From: Amanda Scholes on behalf of Planning.Responses
Sent: 21 May 2019 10:38
To: Planning Scanning
Subject: FW: PLANNING APPLICATION M/42/19/PL 117 ELMER ROAD PO22 6LH
Attachments: PLANNING OBJECTION.docx

PLANNING APPLICATION M/42/19/PL. 117 ELMER ROAD PO22 6LH

parking & vehicular access

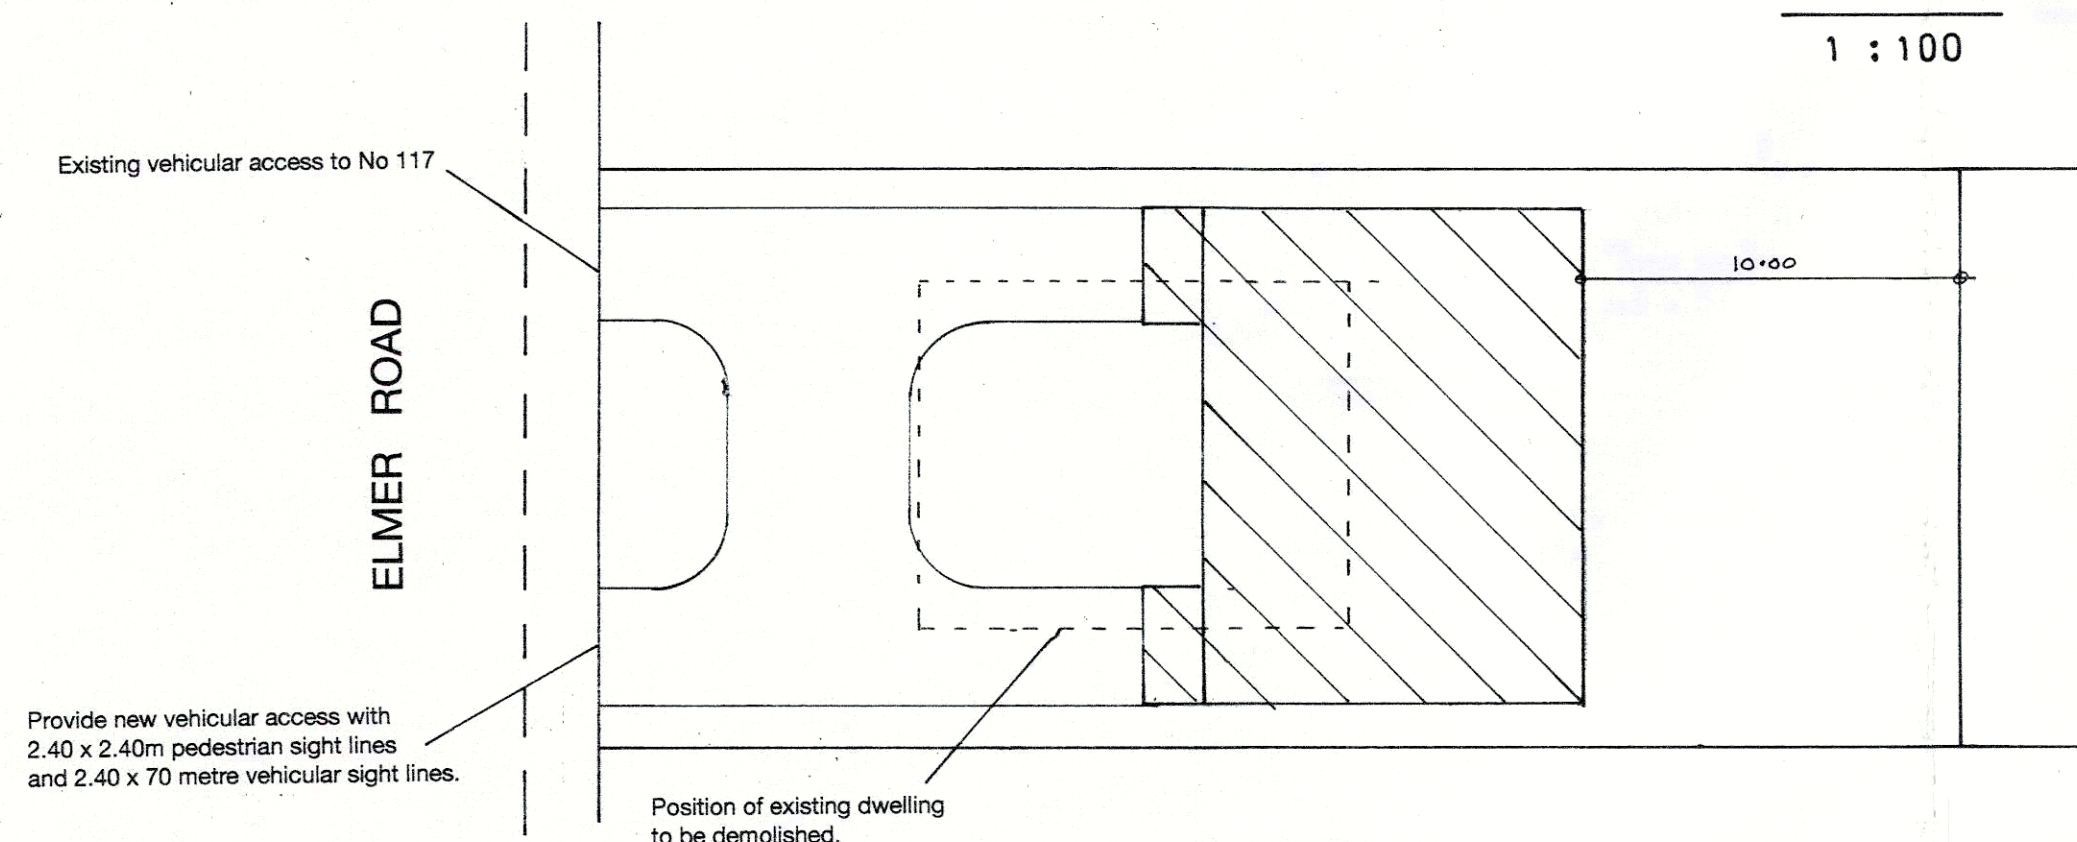
Also, by allowing these two new houses to be set back much further than the existing buildings footprint, would encroach on these creatures' habitat at the rear & furthermore the removal of the front hedges to allow in & out vehicle access could be detrimental to their survival.
